1st Review Final Plat Comment Responses.pdf Markup Summary

SHEET 1 OF 4

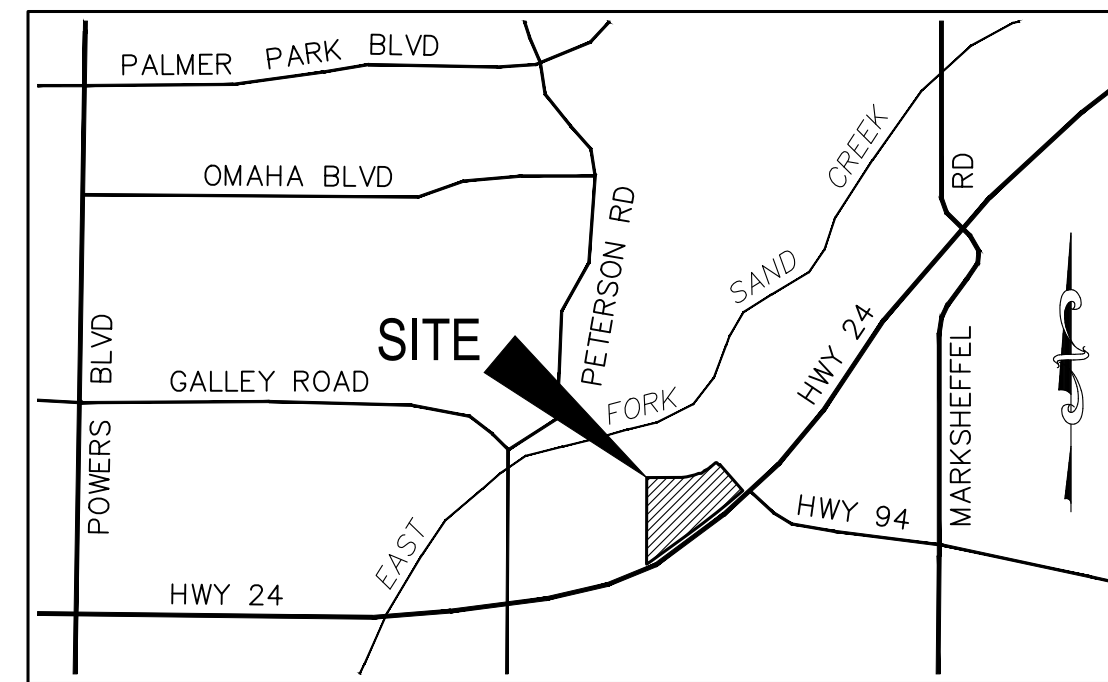
Subject: Architect
Page Label: Sheet 1 - Cover
Author: Ryan Howser
Date: 2/3/2023 2:57:49 PM
Status:
Color: ■
Layer:
Space:

Leave these blank

Subject: Architect
Page Label: Sheet 1 - Cover
Author: Ryan Howser
Date: 2/3/2023 2:58:12 PM
Status:
Color: ■
Layer:
Space:

Remove the word "interim"

Subject: Callout
Page Label: Sheet 1 - Cover
Author: lpackman
Date: 2/1/2023 3:11:57 PM
Status:
Color: 
Layer:
Space:

EPC's EDARP File Number: SF2238" (with no dashes or extras zeros or extra spaces in the file number)

Subject: Callout
Page Label: Sheet 1 - Cover
Author: Ryan Howser
Date: 2/3/2023 3:04:24 PM
Status:
Color: 
Layer:
Space:

Remove the text "use which are applicable"

Subject: Text Box
Page Label: Sheet 1 - Cover
Author: Ryan Howser
Date: 2/3/2023 2:59:50 PM
Status:
Color: 
Layer:
Space:

Include the following:

Name, address and telephone number of the owner of record located in the lower right hand corner,

Date of preparation, date of survey (if applicable), north arrow, written and graphic scale located in the lower right hand corner of each sheet,

Names, address, and telephone number of person(s) responsible for preparing the plat (e.g., licensed surveyor, licensed engineer or designer of the plat) located in the lower right hand corner (if applicable),

Date of submission with provisions for dating revisions located in the lower right hand corner

Fee lines left blank.

"Interim" removed.

File number updates as directed.

Text removed.

Name, address, and phone of owner added to the lower right corner of the cover sheet.

Date of preparation included on all sheets.
Graphic scale and north arrow not added to cover sheet or notes sheet (pages 1 and 2); graphic scale and north arrow included on "as platted" and "as replatted" sheets (pages 3 and 4.

Name of preparer added above company address and phone number in the lower right hand corner.
Name of licensed surveyor included in the Surveyor's Certificate.

SHEET 2 OF 4

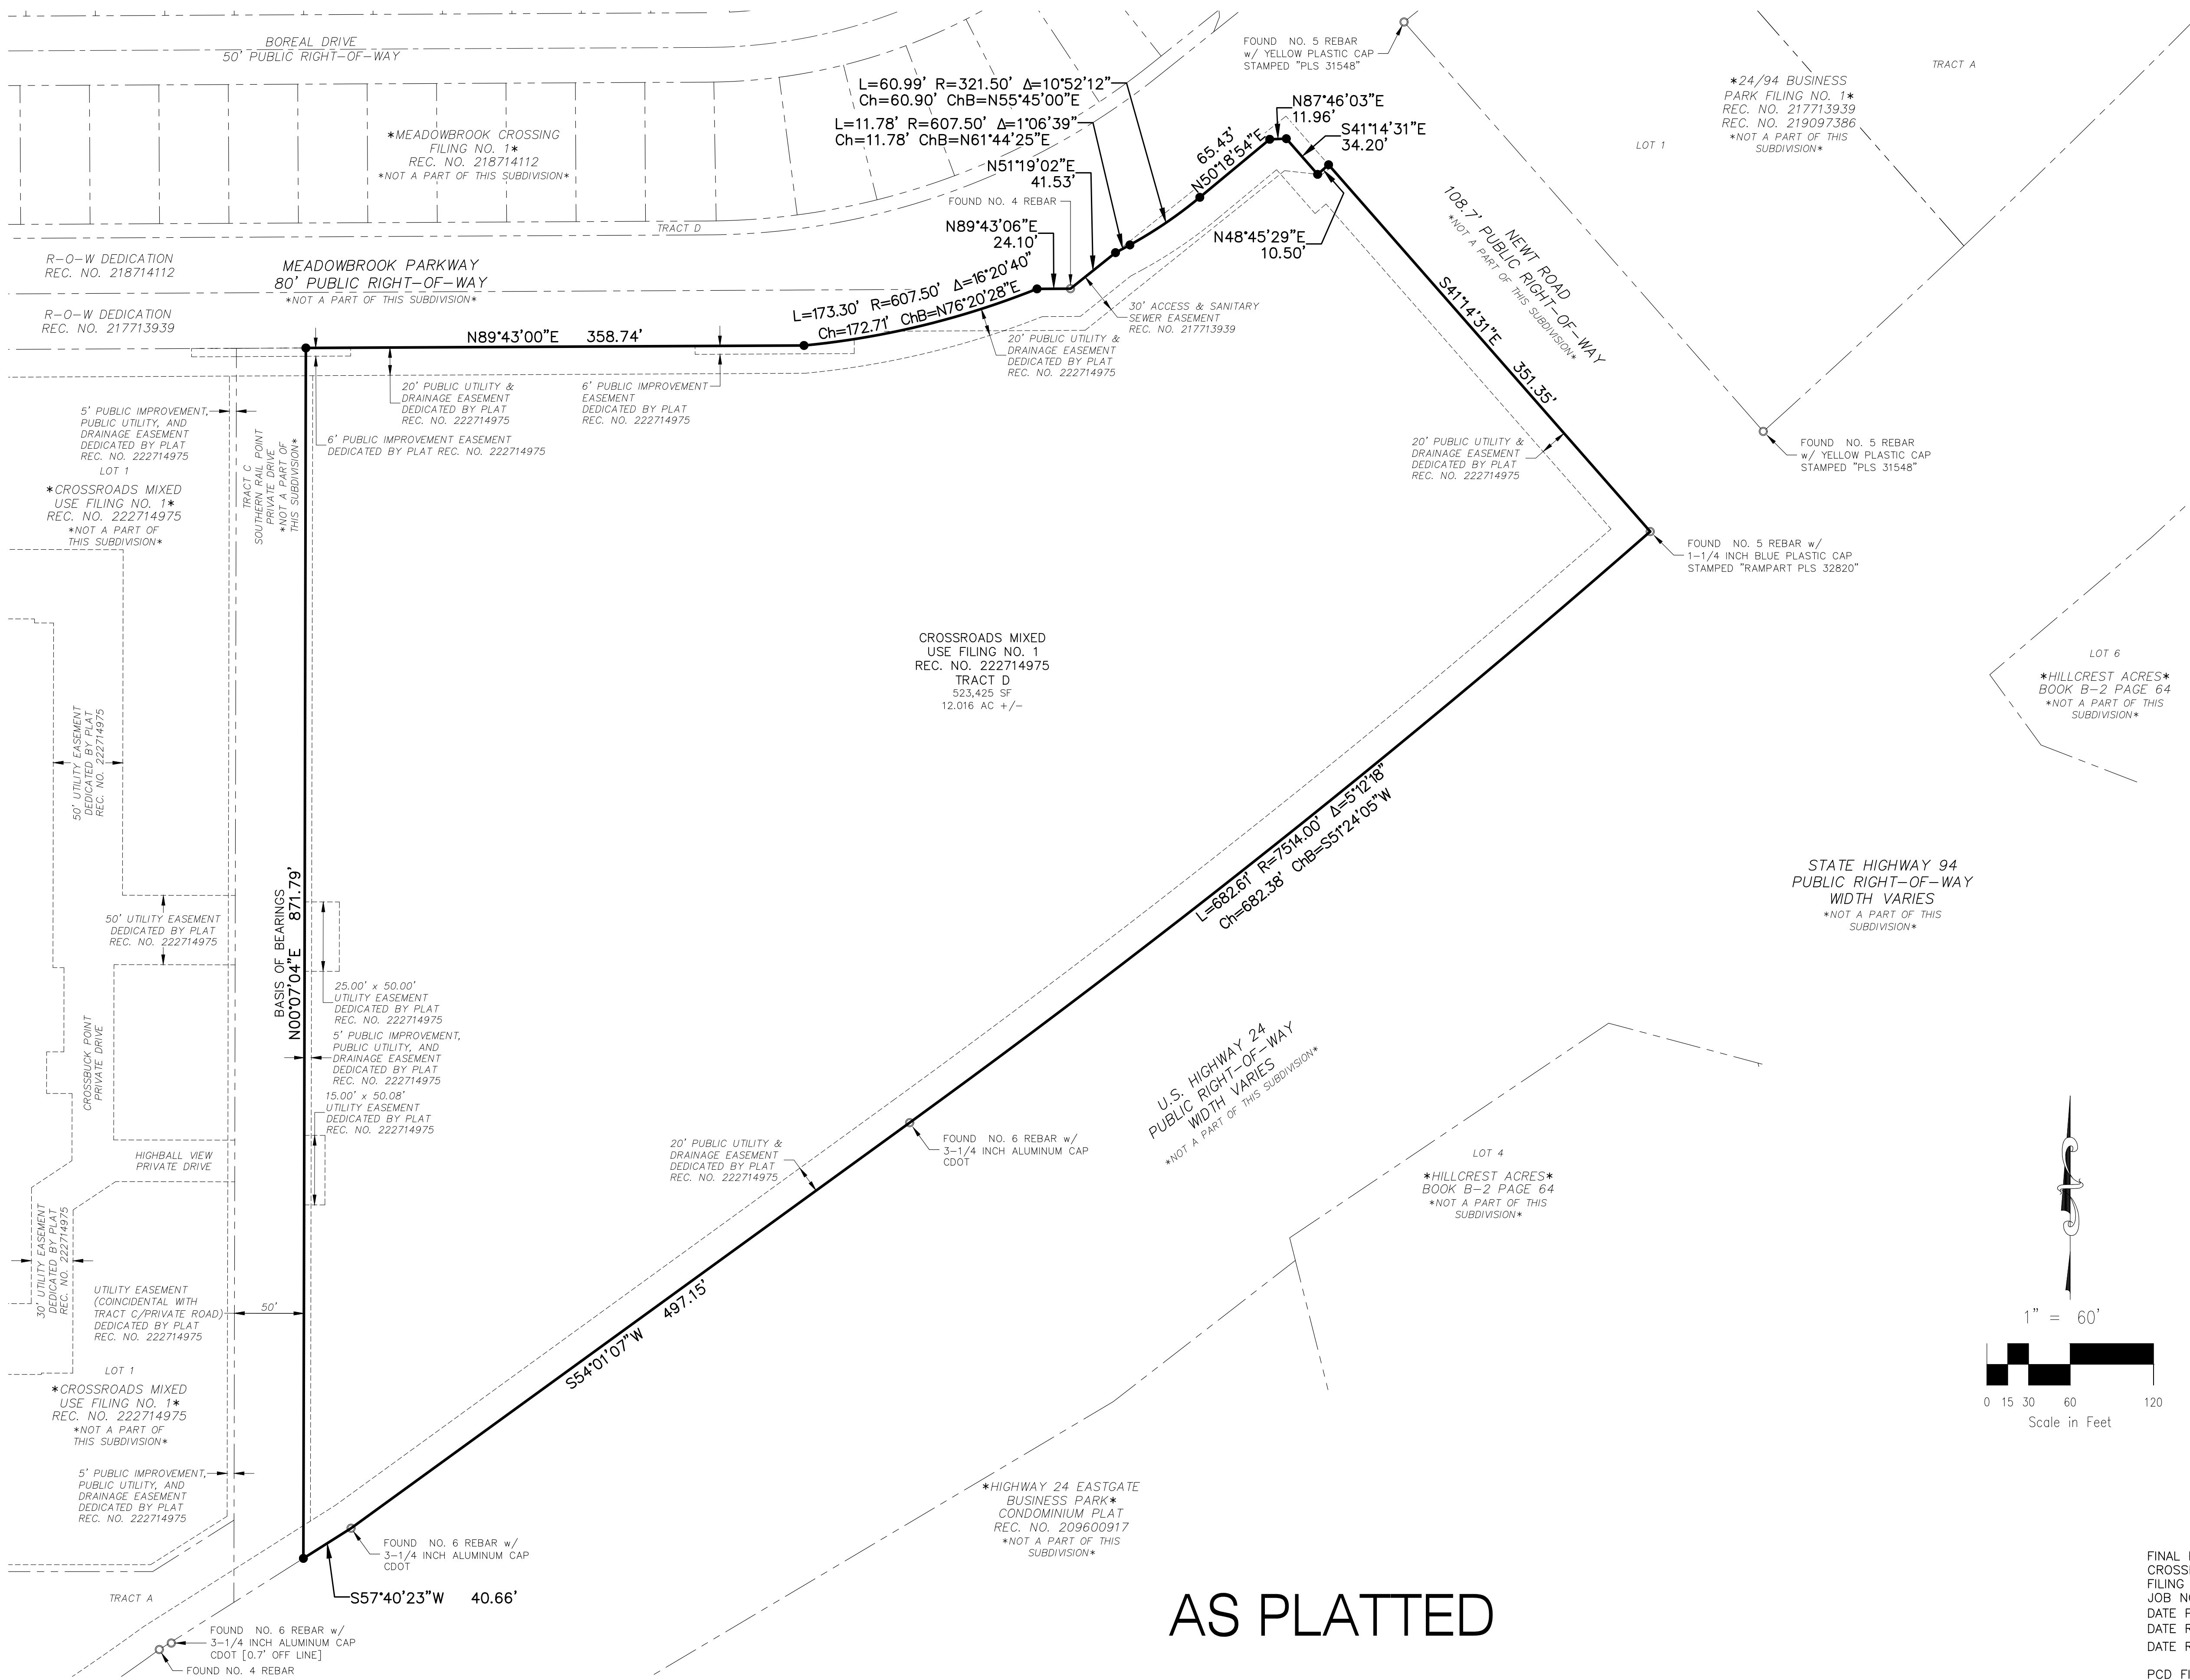
Subject: Architect
Page Label: Sheet 2 - Notes
Author: Ryan Howser
Date: 2/3/2023 3:01:37 PM
Status:
Color: ■
Layer:
Space:

Please include the rest of the reports that were submitted

Subject: Soils & Geology
Page Label: Sheet 2 - Notes
Author: Ryan Howser
Date: 2/3/2023 3:02:48 PM
Status:
Color: 
Layer:
Space:

Update Note 20:
Geologic Hazard Note-Final Plat: (to be customized based upon the individual circumstances)
The following lots have been found to be impacted by geologic hazards. Mitigation measures and a map of the hazard area can be found in the report (Title of Report, generally from the Preliminary Plan file) by (author of the report) (date of report) in file (name of file and file number) available at the El Paso County Planning and Community Development Department:
▪Downslope Creep: (name lots or location of area)
▪Rockfall Source:(name lots or location of area)
▪Rockfall Runout Zone:(name lots or location of area)
▪Potentially Seasonally High Groundwater:(name lots or location of area)
▪Other Hazard:
In Areas of High Groundwater:
Due to high groundwater in the area, all foundations shall incorporate an underground drainage system.

List of reports updated with those found as part of the submittal, per EDARP.

Note not yet updated, as the soils & geology report from EDARP was in question. Waiting to hear back from RMG regarding an update to the report.

AS REPLATTED

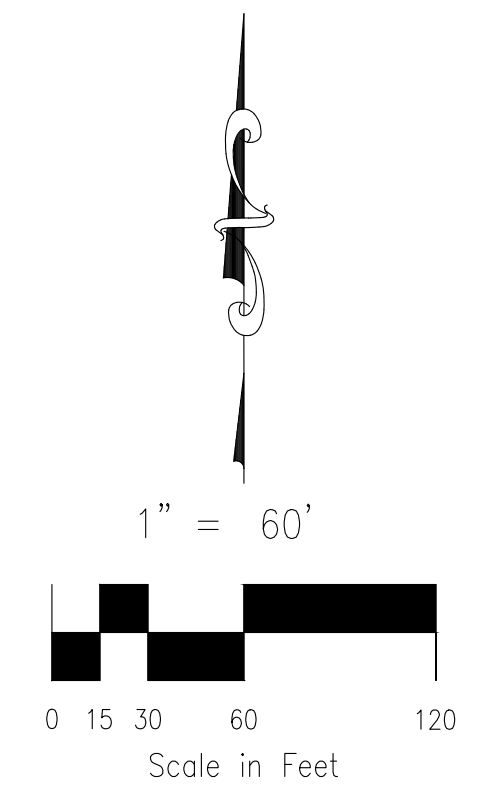
Subject: Cloud
Page Label: Sheet 4 - Replat
Author: eyokom
Date: 2/23/2023 11:22:03 AM
Status:
Color: 
Layer:
Space:

"Way" changed to "Point" per EDARP E911 comments.
